Longview Estates Development

Lahardane, Ballyvolane, Cork

Stage 1/2 Road Safety Audit

Client	Longview Estates Ltd.		
Project Title	Longview Estates Development		
Document Title	Road Safety Audit – Stage 1		
Document No.	19094RS-Doc01		
Job No.	19094RS

| Job No: 17066HD | Drawing No: LHD_PC_P04 | Revision: A |

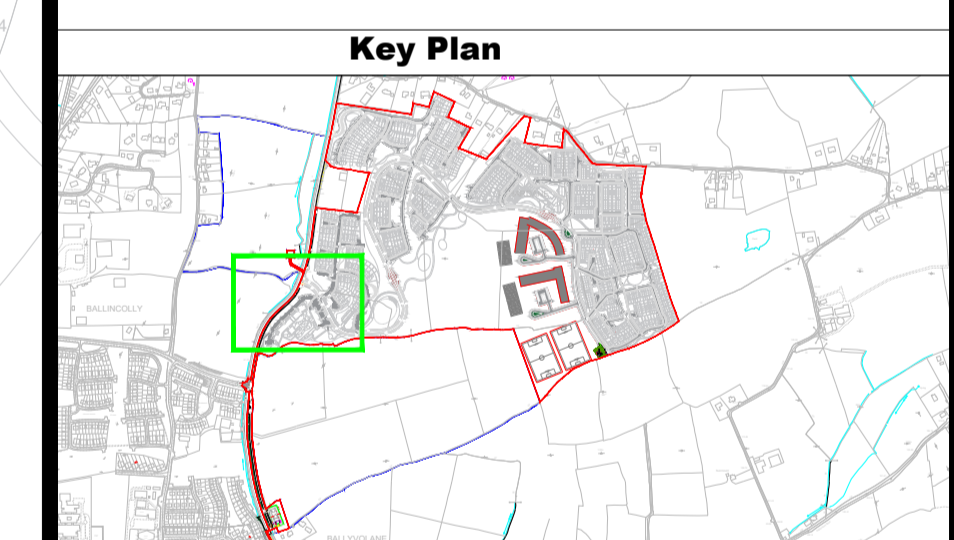
2.3.1 Problem 5: Poor Pedestrian Access to Bus Stop

The bus stop is segregated from the footpath by a two-way cycle facility, essentially creating an "island bus stop". Failure to provide an appropriate crossing detail with signage/markings and tactile paving to inform cyclists of the possibility of pedestrians crossing their path could lead to collisions between pedestrians and cyclists at this location. Refer to Figure 2.3.

2.3.2 Problem 6: Incorrect Tactile Paving Arrangement

The tactile paving arrangement shown at the proposed signalised junction as shown in Figure 2.4 is incorrect. The leg extending away from the road edge should be on the approaching traffic side and it should extend to the back of the footpath. Failure to provide tactile paving to the recommended layouts could lead to confusion for the visually impaired Resulting in potential collisions with passing vehicles.

2.3.3 Problem 7: Inadequate Pedestrian Crossing Width

The width of the proposed crossing is not defined on the drawings. As it is envisaged that both cyclists and pedestrians will want to cross the R614 at this location and the signal aspect diagram indicates same, however there doesn't appear to be adequate width to accommodate both pedestrians and cyclists. Failure to provide appropriate crossing width could lead to collisions between pedestrians and cyclists. Refer to Figure 2.4 above

2.3.4 Problem 8: Unsafe Off Road Cycle Track

The two-way raised off road cycle track from J2 to J3 introduces a contraflow cycle facility arrangement for uphill cyclists, with no protection other than the raised kerb. There is potential for an uphill cyclist (northbound) to wobble out onto the downhill trafficked carriageway with potential for serious vehicle/cycle collisions. As the height of the raised facility is unclear, the higher the kerb the more serious the consequences of a fall from the kerb. See Figure 2.4.

2.3.5 Problem 9: Traffic Signal Pole Arrangement

There appears to be no primary signal head on the left hand side at carriageway level for traffic approaching from the north towards the proposed signalised junction as per Figure 2.4 above. Failure to provide the appropriate signal heads could lead to vehicles being unable to see the traffic signals in advance of the stop line and misinterpreting priority at the junction and leading to collisions with traffic approaching from the Kilbarry Link road. There is also potential for rear end shunt collisions as drivers become aware of the signal control when it is too late to decelerate over a safe distance.

Provide the appropriate markings/signage and tactile paving to inform all users about a shared surface at this location in accordance with the NTA National Cycle Manual. *Figure 2.3*

Provide the appropriate tactile paving design to inform all road users about the controlled crossing location and form in accordance with the relevant guidelines.

Provide the appropriate crossing width that will incorporate both pedestrians and cyclists in accordance with the relevant guidelines. A combined pedestrian/cyclist facility should normally have a minimum width of 4.0m.

Provide protection to the cyclists by provision of a barrier between the cycle track and the road or green space similar to between J1 and J2 further south.

Review the existing Traffic Signals layout in accordance with the relevant guidelines. Consider use of high level cantilever poles for the northern approach.

Designed: SM	Drawn: SFM	Checked: KM
Scale: 1:500 @ A1	Date: Nov 2019	
Job No: 17066HD	Drawing No: LHD_PC_P06	Revision: A

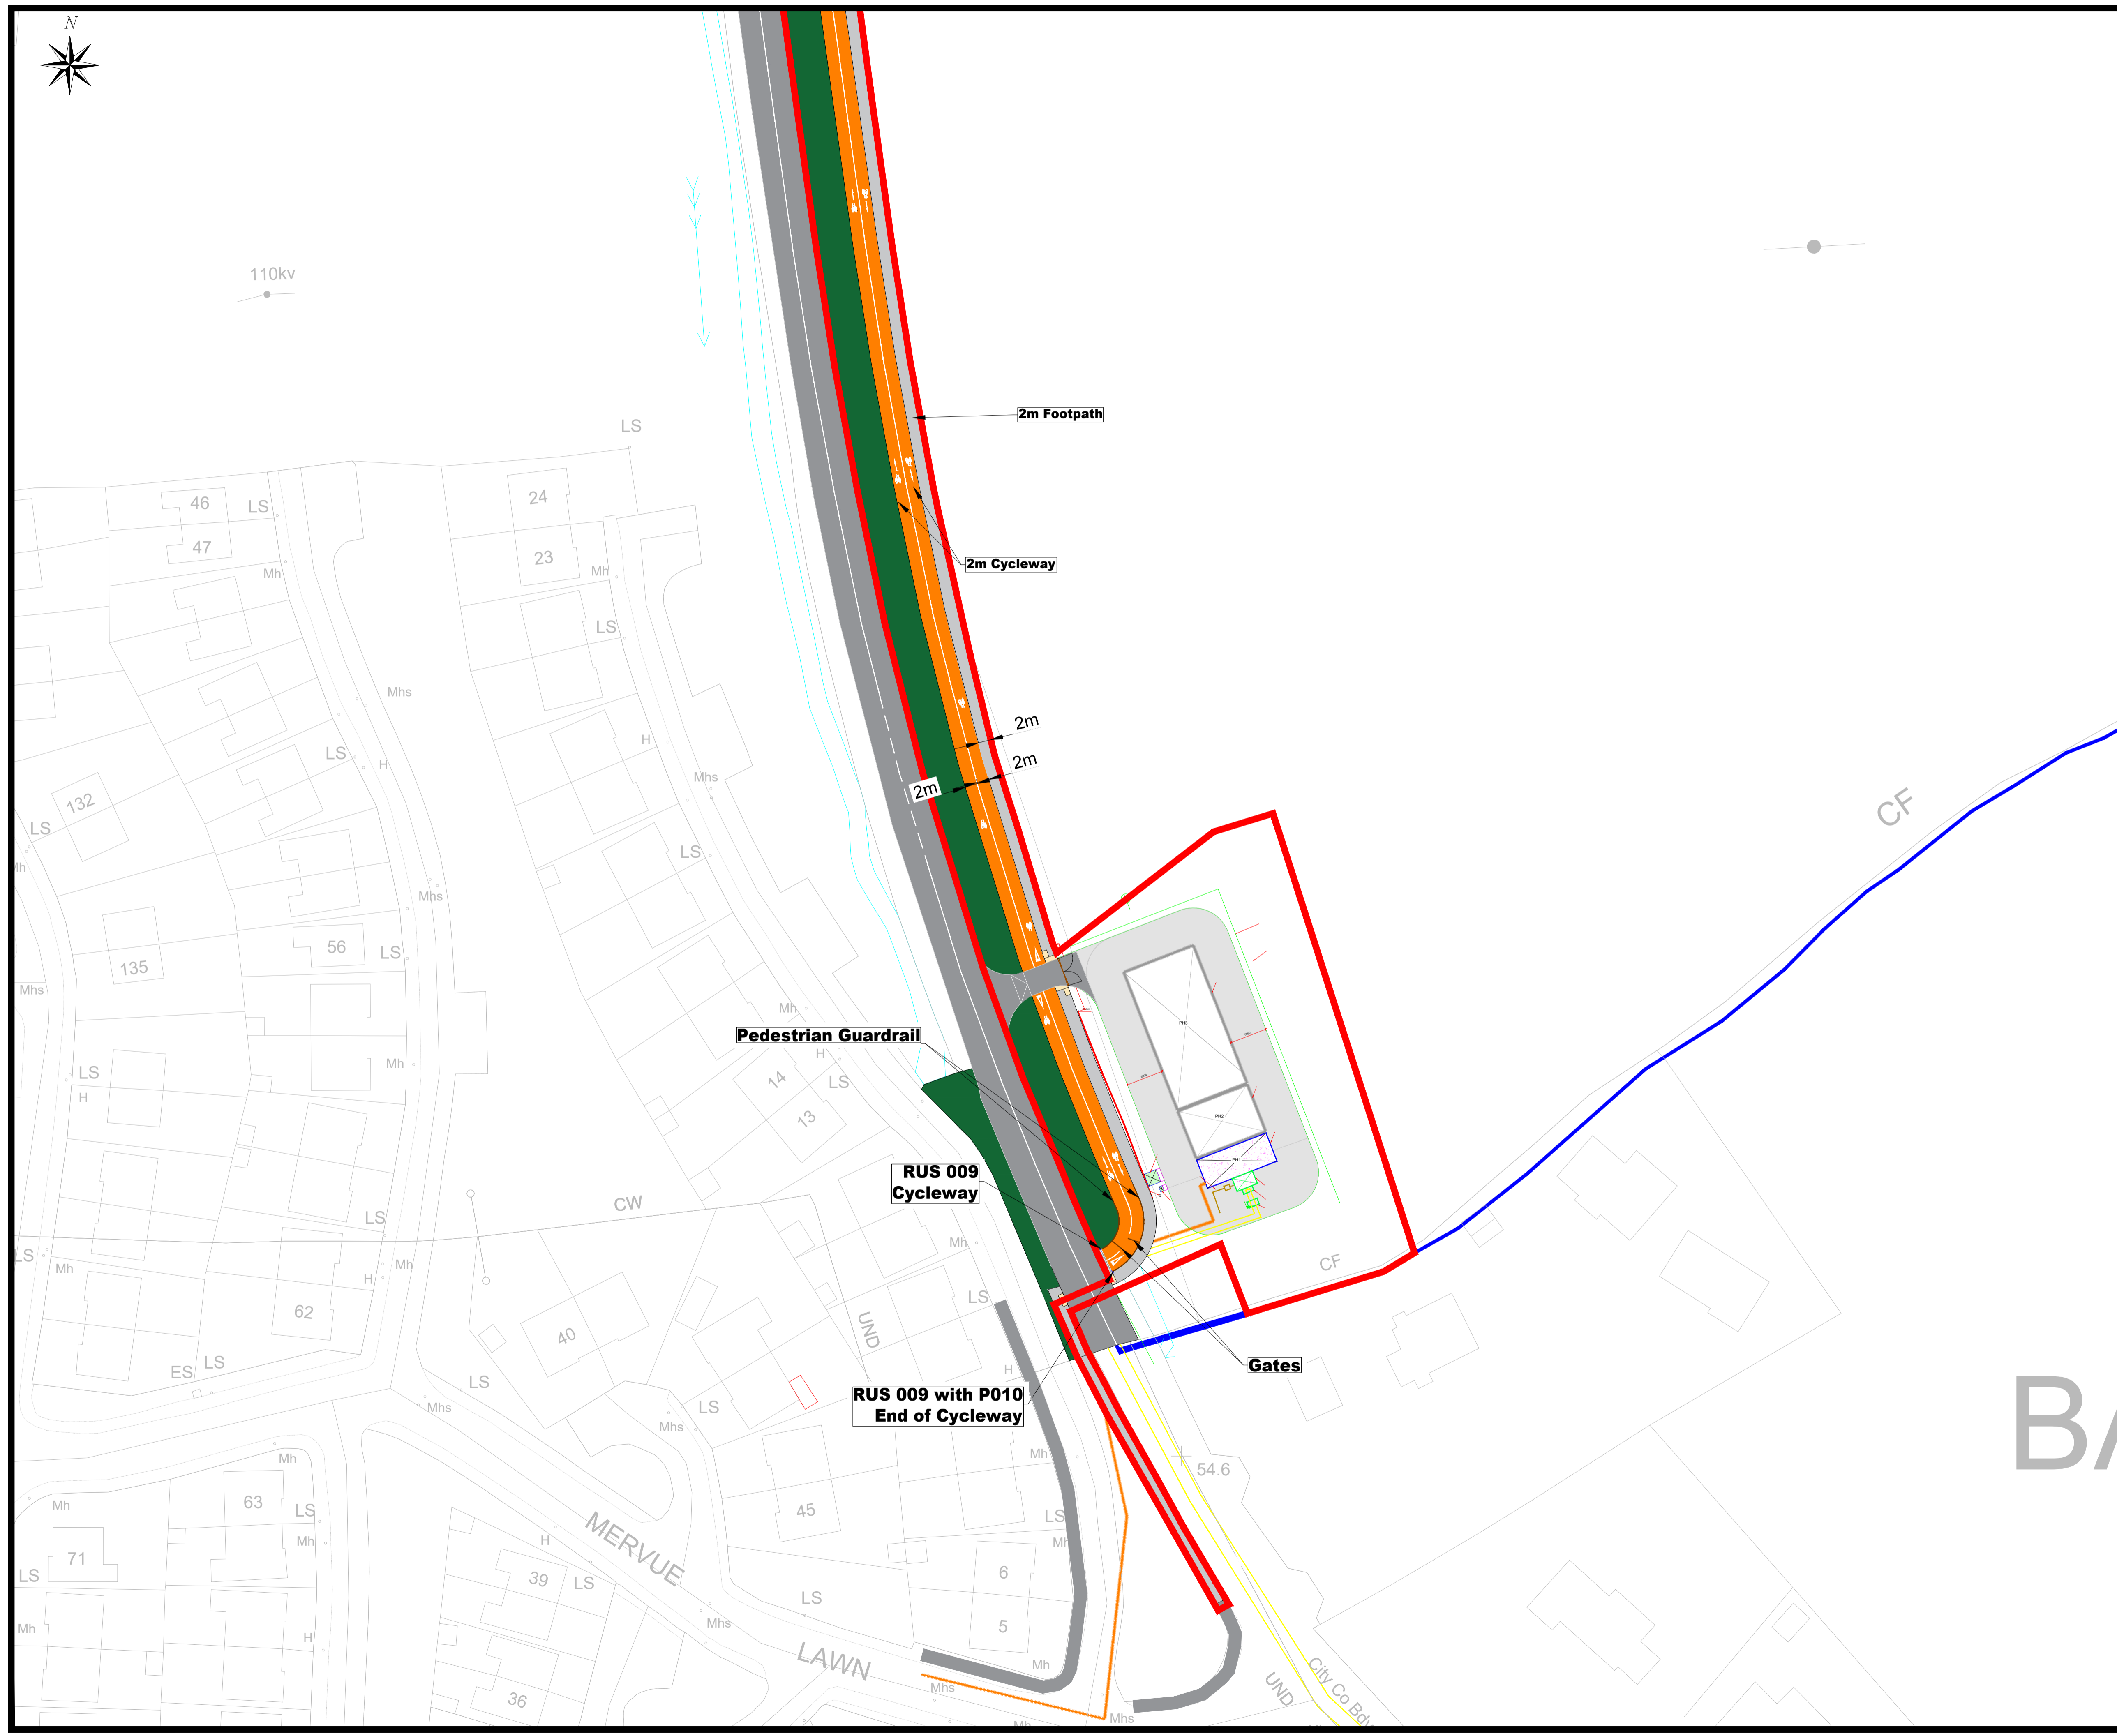
2.4.2 Problem 11: No Pedestrian Crossing at entrance to Development

No provision has been made for pedestrians to cross at the entrance to the development. Failure to provide an appropriate crossing point may lead to pedestrians and or visually impaired users misinterpreting priority at junctions resulting in collisions with entering and exiting vehicles. Refer to Figure 2.5.

2.5.1 Problem 12: No Pedestrian Crossing at entrance to Development

No provision has been made for pedestrians or cyclists to cross at the entrance to the development. Failure to provide an appropriate crossing point may lead to pedestrians or visually impaired users misinterpreting priority at junctions resulting in collisions with entering and exiting vehicles. Refer to Figure 2.6. Refer to Figure 6.

2.5.2 Problem 13: Lack of Footpath connectivity

The footpath/shared surface along the R614 is terminated at approximately 70m south of Junction 4 for a distance of 100m. Failure to provide footpath connectivity along a road will force vulnerable road users to enter the trafficked carriageway leading to potential collisions with passing vehicles. Refer to Figure 2.7.

Provide an appropriate crossing point for pedestrians and all vulnerable road users in accordance with the relevant guidelines. A raised entry treatment should be considered.

Provide the appropriate crossing point for pedestrians, cyclists, *Figure 2.6* mobility impaired and visually impaired users in accordance with the relevant guidelines.

Ensure that footpath connectivity is provided throughout the extent of the scheme works.
